**Consultation Response from KC, Highways Development Management (HDM)**
**2023/92448 Former Cooper Bridge Water Treatment Works, Leeds Road, Mirfield, WF14 0BT**
**Outline application for erection of B8 industrial unit**
**Date Responded: 25/10/23**
**Responding Officer: A Darwin**
**Responding Ref: HDC 10-2NW/1**
**RECOMMENDATION: Further information and amendments required**

3633 100-P-001 B

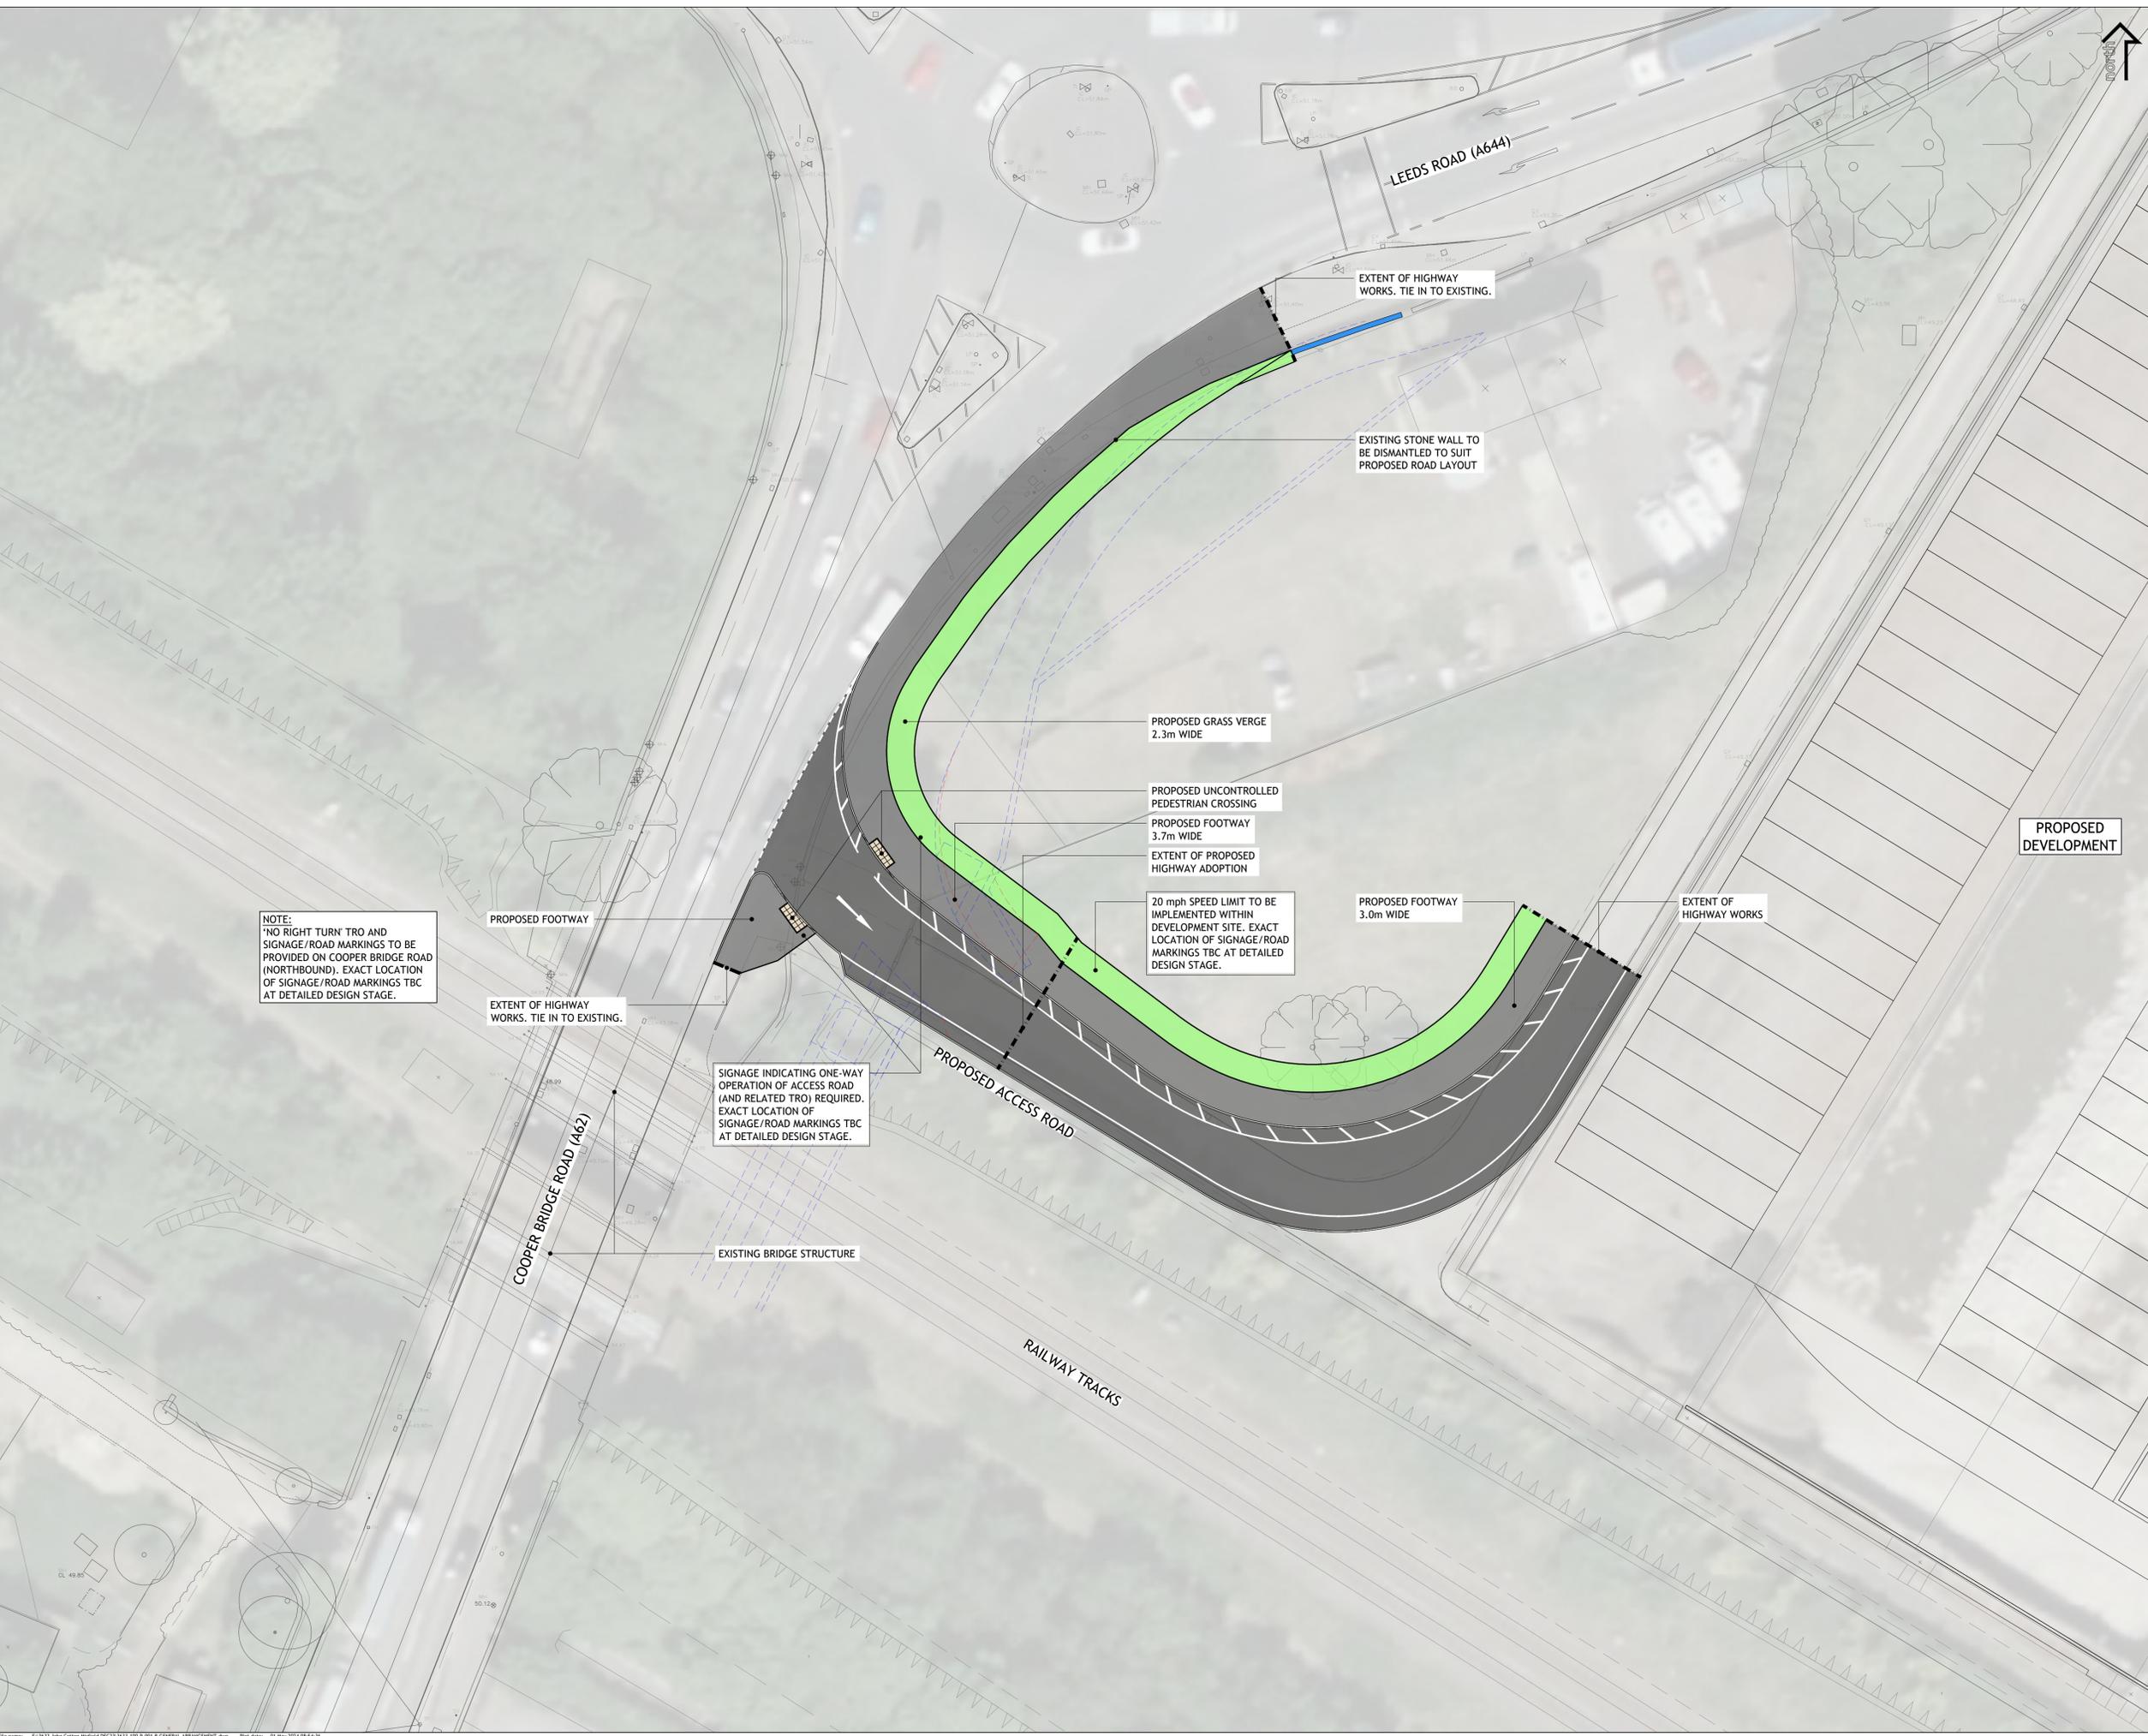
- The proposed entry only access on to Cooper Bridge Road may be acceptable in principle. However, inbound right turn movements are not acceptable at this access for safety/operation reasons; and are likely to result in rear shunt incidents associated with the lack of any right turn lane facilities, as well as right turning incidents associated with the close proximity of the signalised roundabout to the north. These problems would be further exacerbated once the A62 to Cooper Bridge Corridor Improvement Scheme is delivered, which are currently envisaged to include two southbound lanes on Cooper Bridge Road. Therefore, only a left in access could be accepted in this location, which would require any northbound development traffic on Cooper Bridge Road to circulate Cooper Bridge Roundabout (or the revised gyratory system currently being developed) before entering via this access.

- As only left in access could be accepted, physical measures to prevent right turn movements into the site access should be provided. However, as there are width constraints on Cooper Bridge Road that will not allow this in the interim situation (a separation island can be implemented later with the A62 to Cooper Bridge Corridor Improvement Scheme), the only physical measures that are likely to be possible in the interim situation would relate to the alignment of the access to discourage right turn movements, and in particular HGV's, which must be incorporated into the proposals.

- To further discourage right turn movements into this site access, it is suggested that a 'no right turn' TRO and signage/markings are provided on Cooper Bridge Road. Based on HDM's initial discussions with their counterpart at Calderdale Council, it was considered that in principle a TRO of this type may be acceptable in this situation.

- Whilst a left in access on Cooper Bridge Road may be acceptable in principle, the arrangements currently proposed are unacceptable. The access must be designed in accordance with DMRB standards, which require (see 5.6.2 of CD 123) 15m corner radii, with a corner taper of 1:10 over a distance of 25m on the minor arm, to ensure that HGV's traffic can turn left at an appropriate design speed, without causing rear shunt type incidents. In addition to these junction geometry requirements, right turn movements into the access need to be actively discouraged as mentioned above. The minor arm of the site access also needs to be of sufficient width to allow an inbound HGV's to pass a stationary vehicle (either parked or broken down), to ensure that blocking back onto the highway does not occur.

- Careful design of the cycle/footway crossing of the site access arm also needs to be considered in the design, as well as safe pedestrian/cycle access to/from the site.

- Based on the necessary changes to this site access design, it is clear that land beyond the applicants site boundary to the north (that has been procured by Kirklees Council to deliver the wider Cooper Bridge improvement scheme) will be required to deliver an acceptable access arrangement, and the redline boundary for the planning application will need to be amended (HDM have already identified this matter to the Planning Officer).

- In addition to the above requirements, land must be safeguarded within the site, which will enable the access to be amended in future to accommodate the A62 to Cooper Bridge Corridor Improvement Scheme. This will need to be discussed further with Kirklees Highways Major Projects Team. However, it is noted that a left in access as described above appears to be achievable.

In light of the above, significant changes are required to the Cooper Bridge Access arrangements, which must be designed to work with the current highway arrangements and the future A62 to Cooper Bridge Corridor Improvement Scheme. Updated plans are required of these revised access proposals, which should be fully dimensioned and include swept path analysis (SPA) of HGV's that have been undertaken at an appropriate design speed (to be confirmed in the SPA report).

3633 100-P-002 B

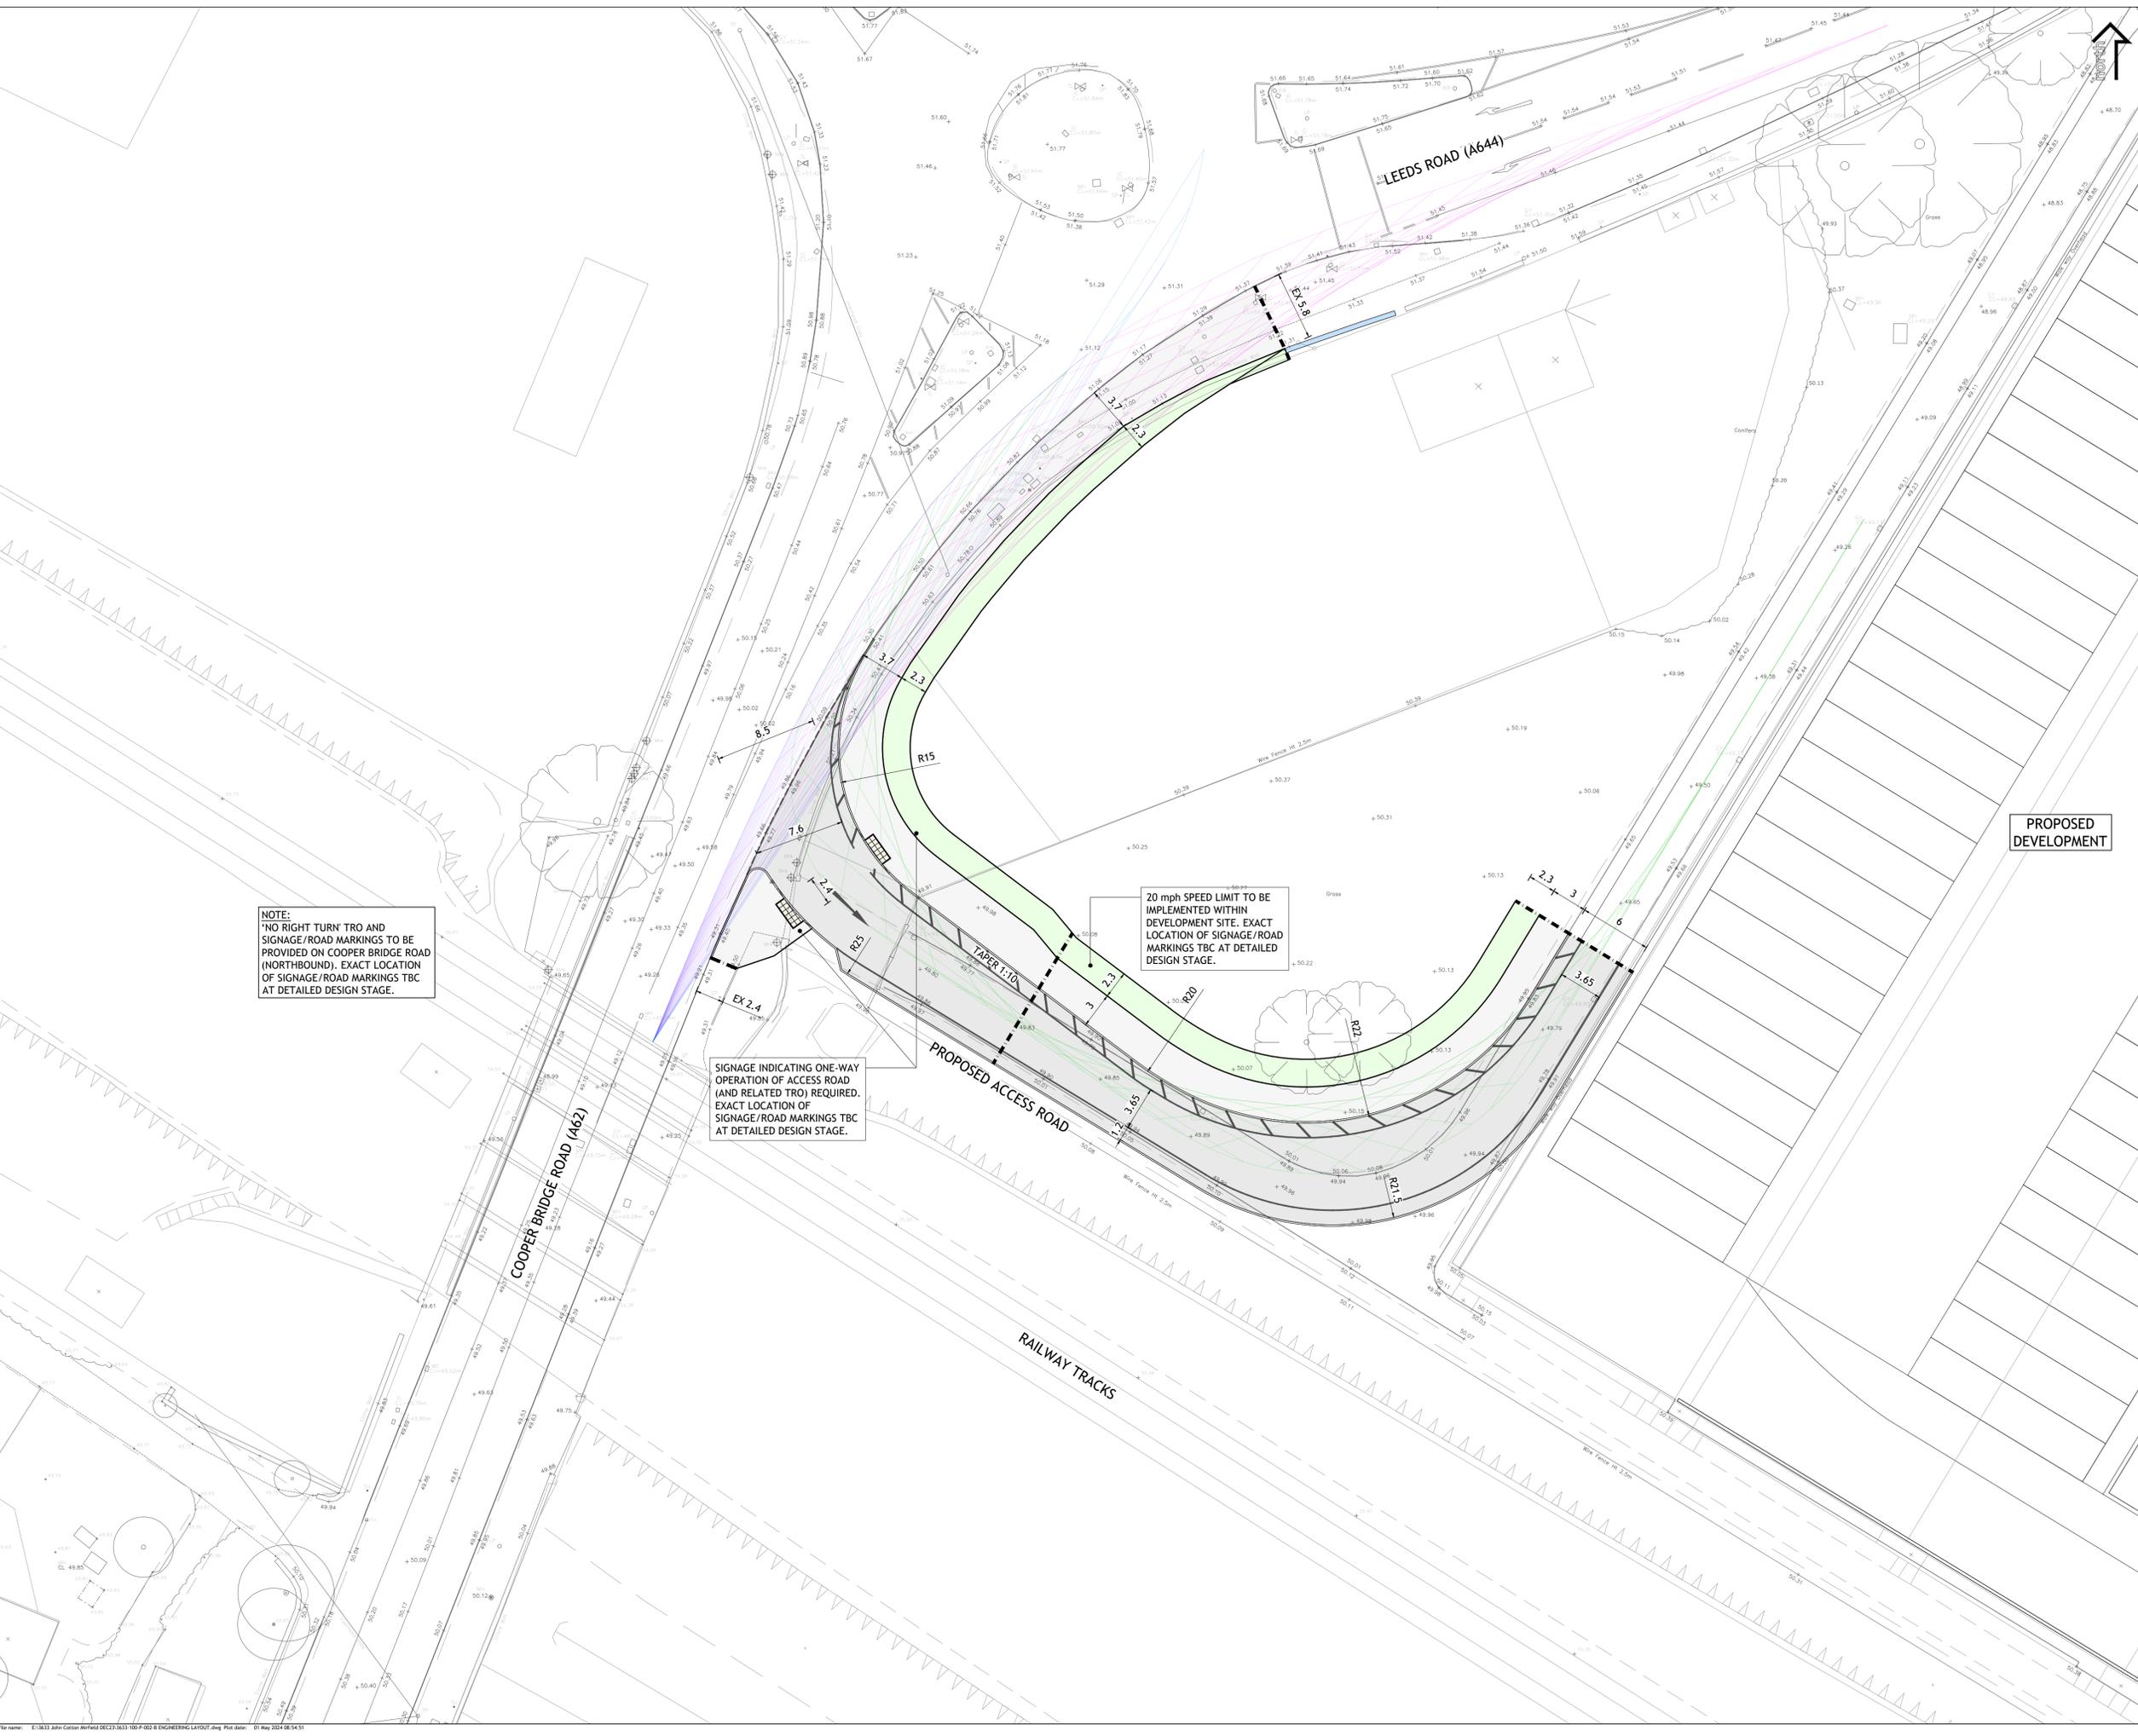
- A right turn lane is proposed at the upgraded site access junction on Huddersfield Road, which is proposed to replace the existing hatch markings. However, the layout of the right turn lane is not in accordance with DMRB standards, which includes a lack of adequate deceleration length, storage length, taper and lane width. These deficiencies cannot be addressed due to the location of the adjacent traffic signals, and are significant road safety concerns that could result in rear shunt collisions, late braking and blocking back to the traffic signals.

- As adequate right turn lane facilities cannot be provided at the site access, it is suggested that this movement is prevented through the introduction of a physical segregation island, which appears to be achievable for both the interim situation and with the A62 to Cooper Bridge Corridor Improvement Scheme by extending the existing physical island at the signalled junction passed the site access in the existing hatched area. Whilst preventing right turners into this access will alter the access strategy for the development, this arrangement would still enable access to the site, subject to the left in access only on Cooper Bridge Road being achievable and being made available for both HGV's and staff traffic.

- Following consultation with the Councils Road Safety team, significant concerns have been raised regarding right turning vehicles exiting the site access on to Huddersfield Road, as this traffic would need to turn right through westbound queuing traffic at the adjacent traffic signals, which would significantly restrict visibility and create unsafe turning manoeuvres. It is noted that this safety problem has already been acknowledged by the applicant, as they have installed informal 'no right turn' signage at this existing access.

- As safe turning for right turners out of the access cannot be achieved, it is suggested that right turn movements from the site access are again prevented through the introduction of a physical segregation island as mentioned above. Whilst preventing right turners out of the access will alter the access strategy for the development, development traffic will still be able to head east on Huddersfield Road, but would need to first circulate the highway network via the Cooper Bridge Roundabout for these journeys (which will still be possible with the A62 to Cooper Bridge Corridor Improvement Scheme in place).

- No details of junction visibility have been confirmed in the Transport Assessment or the supporting plans. However, it is clear that junction visibility to the right on exit of the site access is not in accordance with DMRB requirements (e.g. below 2.4x120m based on 40mph speed limit) and is severely sub-standard. It is noted that it may be possible to address this issue by setting back the boundary wall in the existing John Cotton site to the east of the access. However, this will have implications on the existing parking area and service yard, and the necessary amendments need to be identified. It is noted that these changes will also require further changes to the planning application red line boundary.

- The site access plans do not currently acknowledge the existing cycle lanes on Huddersfield Road, or provide suitable arrangements for pedestrians and cyclists, which must be incorporated into the design.

In light of the above, significant changes are required to the Huddersfield Road access arrangements, which must be designed to work with the current highway arrangements and the future A62 to Cooper Bridge Corridor

Improvement Scheme. The only feasible option appears to be a left in/left out priority junction (or alternatively a fully signalised junction could be considered, although traffic capacity issues are likely to preclude this as an option). Updated plans are required of these revised access proposals, which should be fully dimensioned and include swept path analysis (SPA) of HGV's that have been undertaken at an appropriate design speed (to be confirmed in the SPA report).
